WEST SUSSEX COUNTY COUNCIL CONSULTATION

TO:	Arun District Council FAO: Michael Eastham
FROM:	Stephen Gee WSCC - Highways Authority
DATE:	5 May 2021
LOCATION:	Land at Dappers Lane Angmering Littlehampton
SUBJECT:	A/79/21/DOC Approval of details reserved by condition imposed under ref A/76/20/PL relating to Condition Nos 6 - Construction Management Plan and 27 - soils management plan.
DATE OF SITE VISIT:	n/a
RECOMMENDATION:	More Information
S106 CONTRIBUTION TOTAL:	n/a

The following comments are provided relating to Condition 6 - Construction Management Plan

Appendix A
Construction Access Map

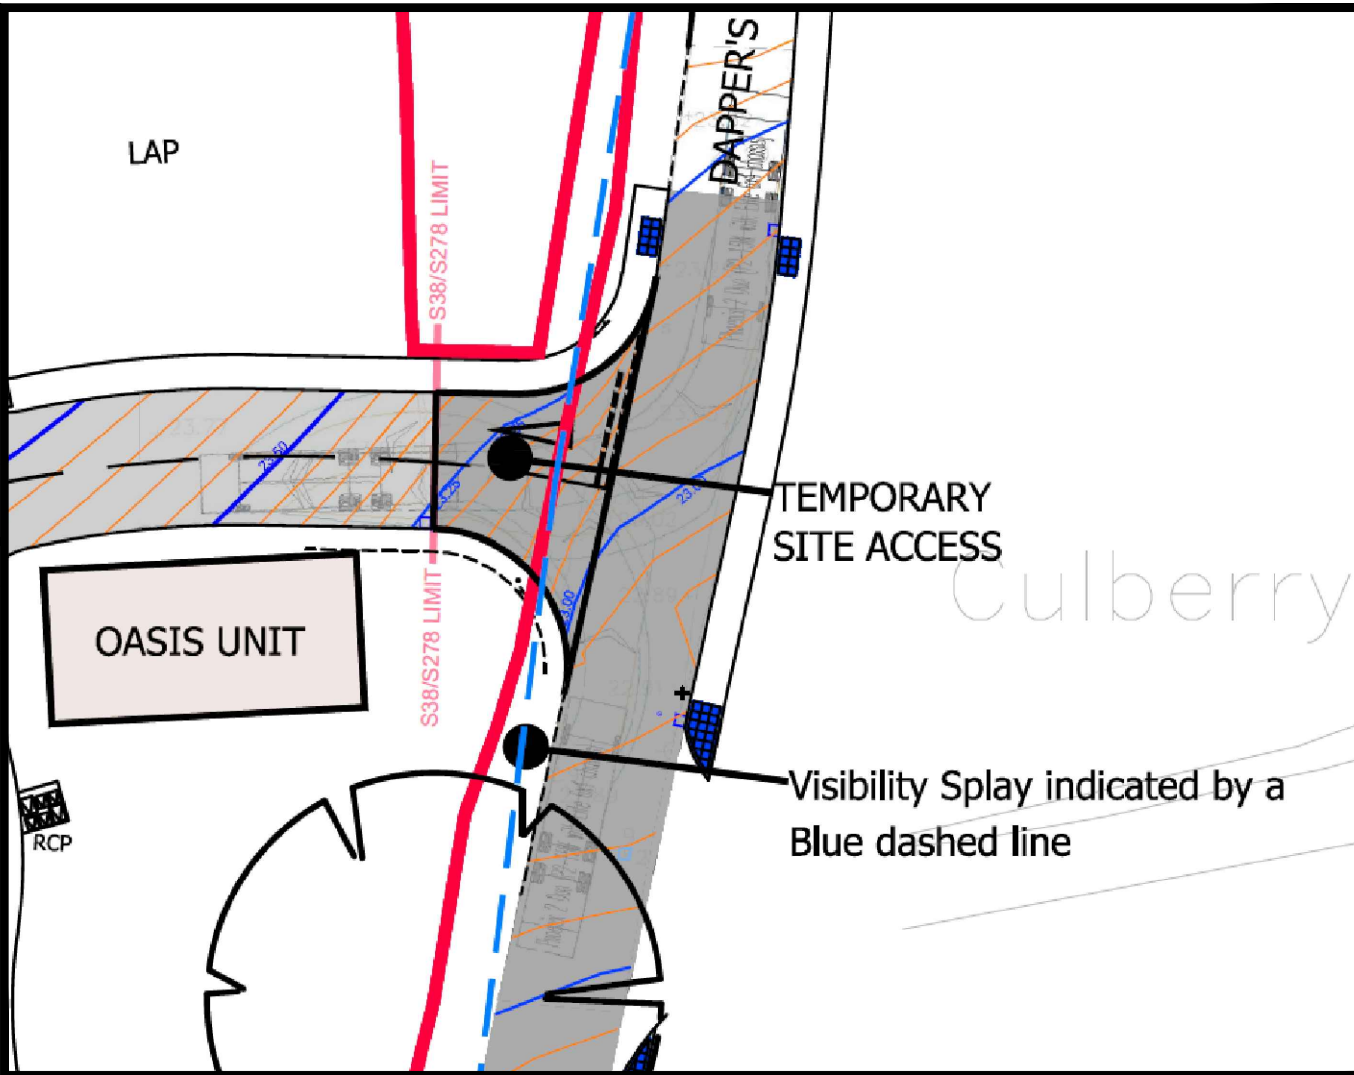
The document indicates that vehicles will be routed from Dappers Lane via Water Lane. No information is provided on the route towards the A27.

The CEMP indicates incorrectly that Dappers Lane is subject to a 20mph speed limit.

Further Information on the anticipated number of construction vehicles and routing should be provided.
